Application by FVS Dean Moor Limited for Dean Moor Solar Farm

The Examining Authority's written questions and requests for information (ExQ1)

Issued on 25 July 2025

Environmental Statement: Chapter 2 – Figure 2.1 Cumulative Schemes within 10km of the Order Limits

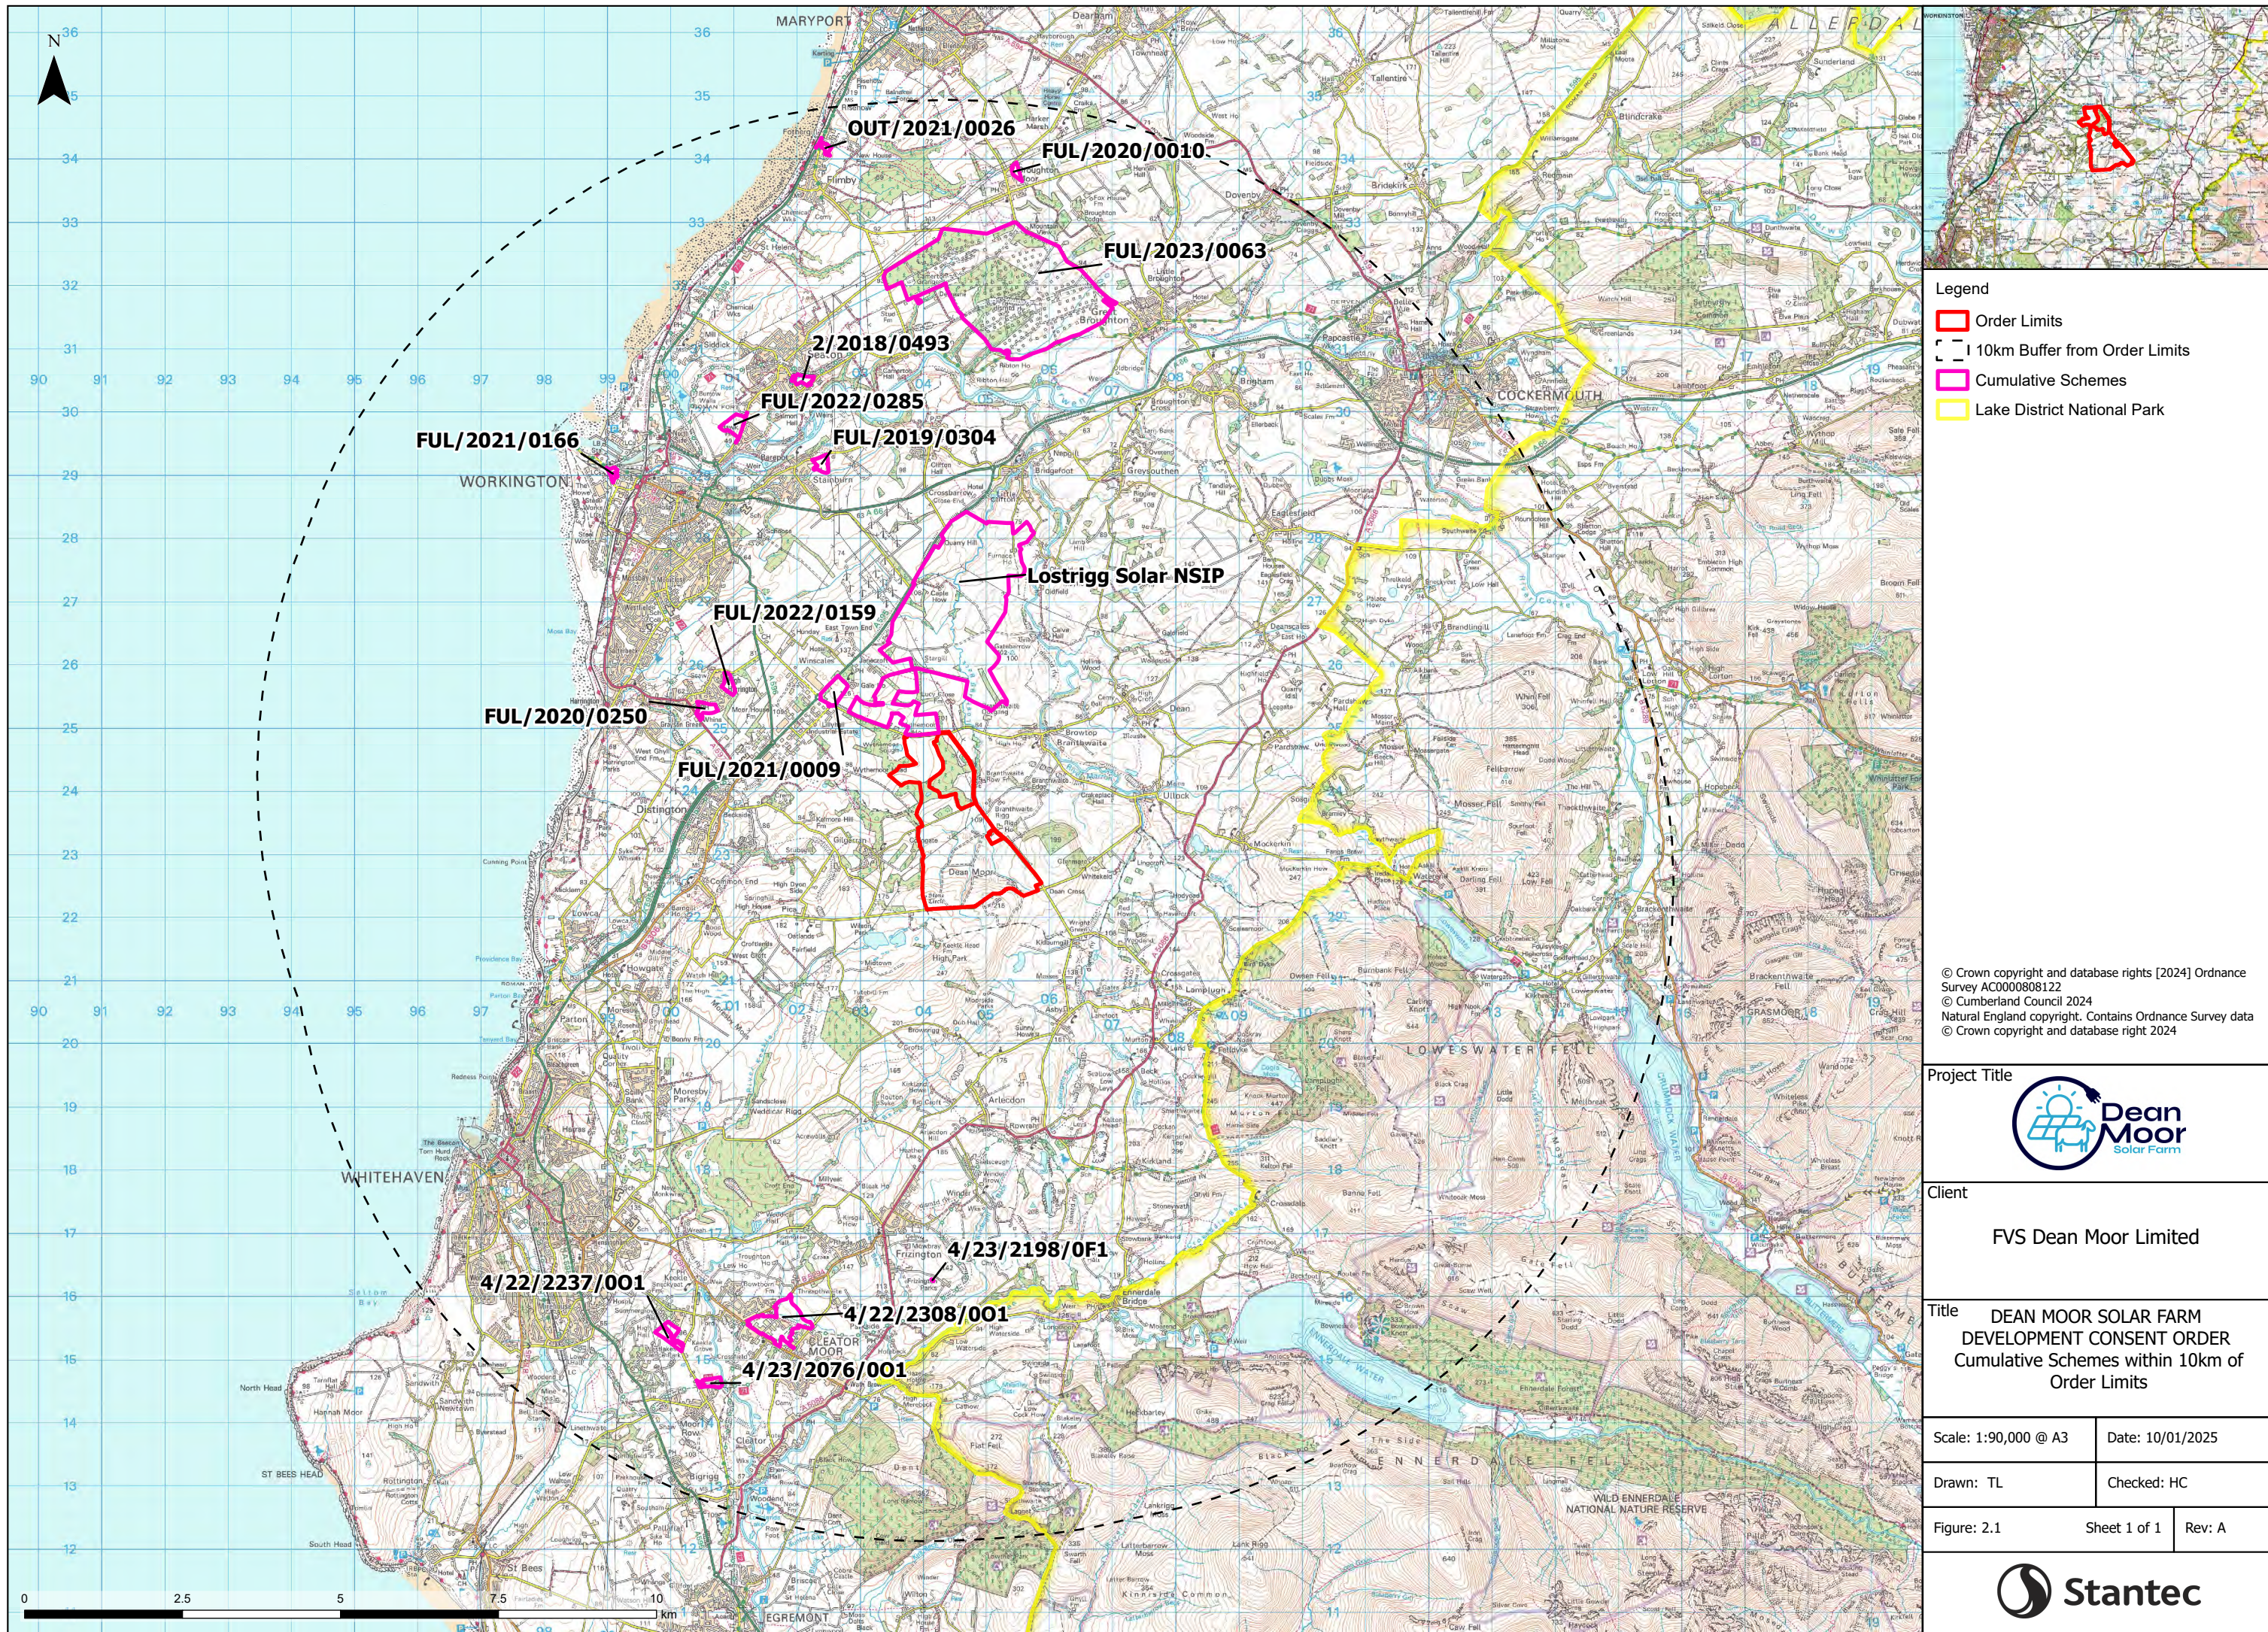
ExQ1	Question to:	Question:
Q4.0.7	Applicant/Cumberland Council	ES chapter 2 – please confirm that the list of cumulative schemes set out in table 2.6 is complete and should be used by the ExA to inform the cumulative assessment, otherwise please provide an alternative list. This was also requested by the ExA in relation to a Statement of Common Ground (SoCG) in the rule 6 letter.
Q4.0.8	Applicant	<p>ES Methodology - there is an overlap between a 'live' planning permission and the proposed development, as the land included in the Potato Pot wind farm consent is also within the proposed Order limits. However, limited consideration has been given to the implications of this planning permission, and its likely temporary nature, in relation to the proposed project:</p> <p>The ExA require the following:</p> <ul style="list-style-type: none"> • details of the Potato Pot wind farm consent and a plan showing the site including red-line boundary along with the anticipated decommissioning and removal date • the implications of its future removal on the EIA methodology and ES chapters in terms of the assumptions made concerning the future baseline and/or environmental effects of the proposal and the assessment scenarios set out in the methodology. <p>The above should take into account the following potential issues, whilst also addressing any other implications for the ES:</p> <ul style="list-style-type: none"> • paragraphs 7.4.1 – 7.4.3 of chapter 7 of the ES confirms that Potato Pot wind farm has been considered as part of the 'baseline'. However, no analysis has been provided in relation to its potential temporary nature and the extent to which the wind farm's future decommissioning and removal would alter the landscape, and the extent to which this would alter the magnitude of change and effects associated with the proposal as assumed as part of the Landscape and Visual Impact Assessment (LVIA) • linked to the above, the visualisations include 'Year 15' but it is not clear whether or not the wind farm would be in situ, nor whether the visualisations represent a robust visual representation of the long-term impact of the scheme given the potential removal of the wind farm • as above, implications for chapter 6 of the ES (Cultural Heritage) • any implications for site access <u>including</u> compulsory acquisition/temporary possession in terms of ensuring that it is possible to decommission and remove the wind farm and restore the site • implications of removal of the wind farm and any cabling or other works required by the planning permission and the impact this would have on the proposal and dDCO • having regard to the above, whether the dDCO is sufficiently robust in terms of provisions in order to adequately facilitate the wind farm operation and decommissioning etc.

Environmental Statement: Chapter 6 – Figure 6.1 Designated Heritage Receptors within 3km of the Order Limits

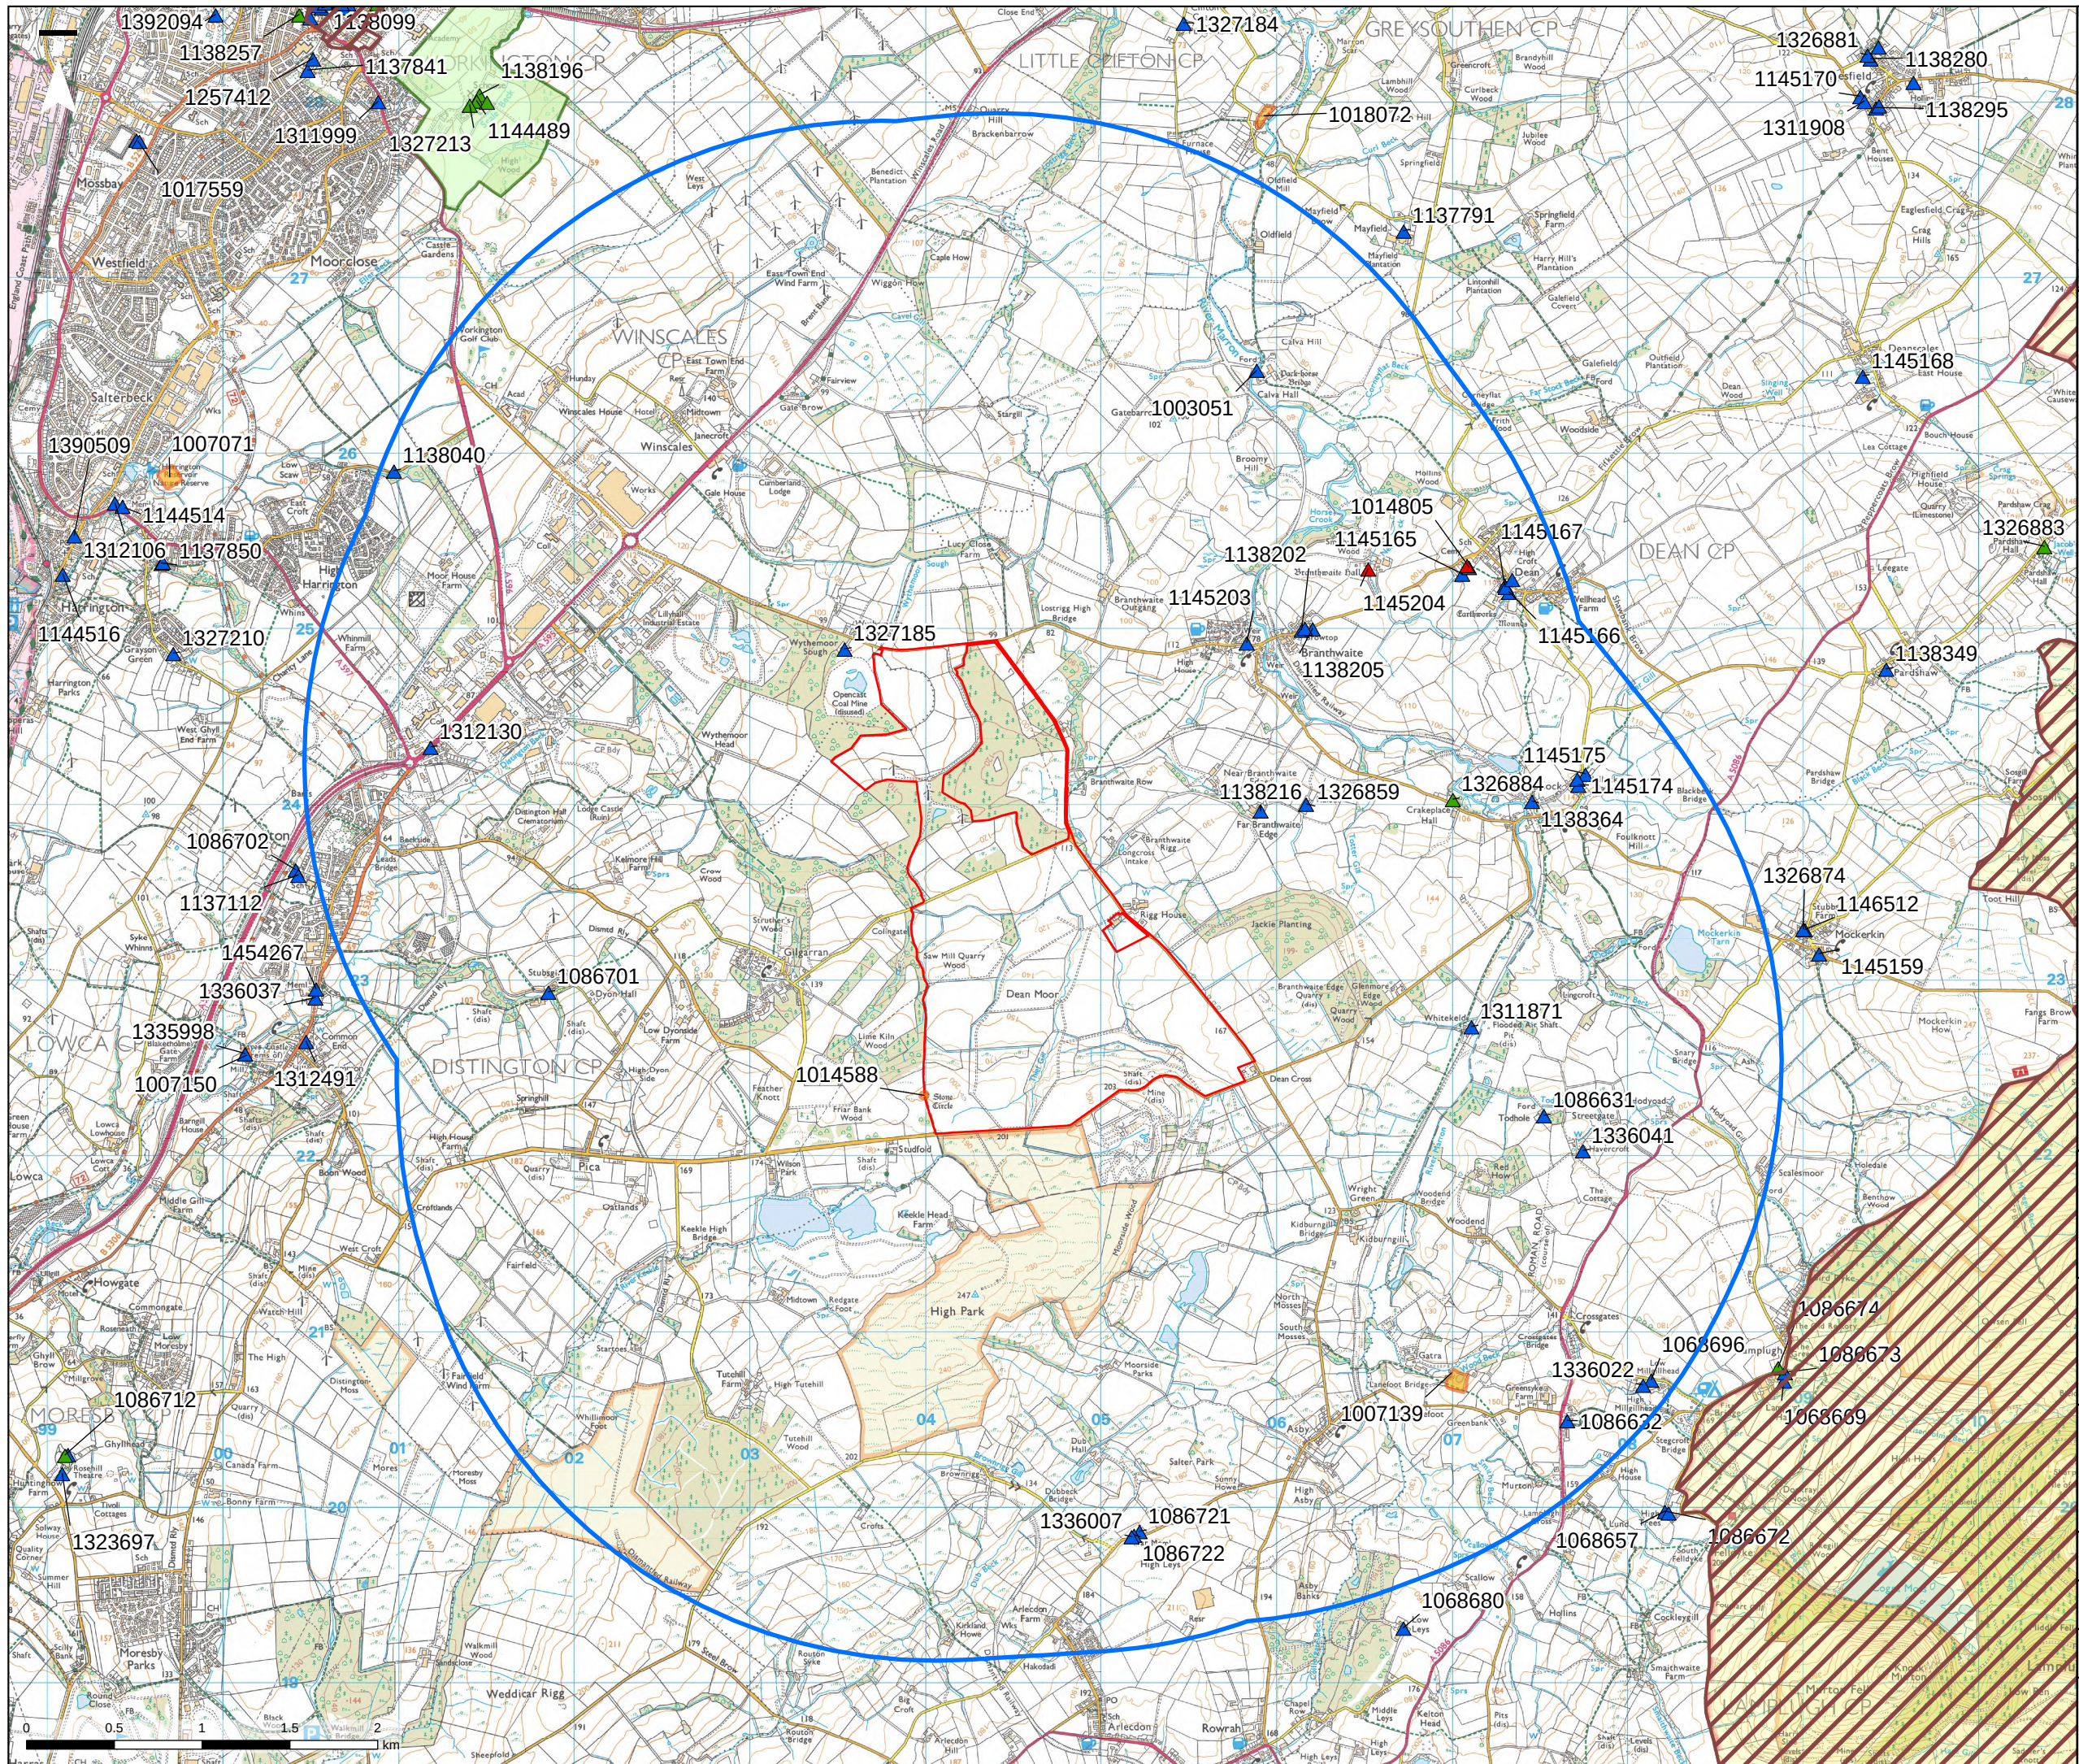
ExQ1	Question to:	Question:
Q5.0.9	Applicant	ES chapter 6 paragraph 6.5.11 states that there is 'no potential for indirect impacts' yet minor adverse impacts are identified in the remainder of the paragraph. Clarify.
Q5.0.10	Applicant	The figure showing Heritage Assets within 3km [APP-076] illustrates that the boundary of Conservation Areas is identical to the boundary of the WHS. Please amend the plan if it is incorrect.
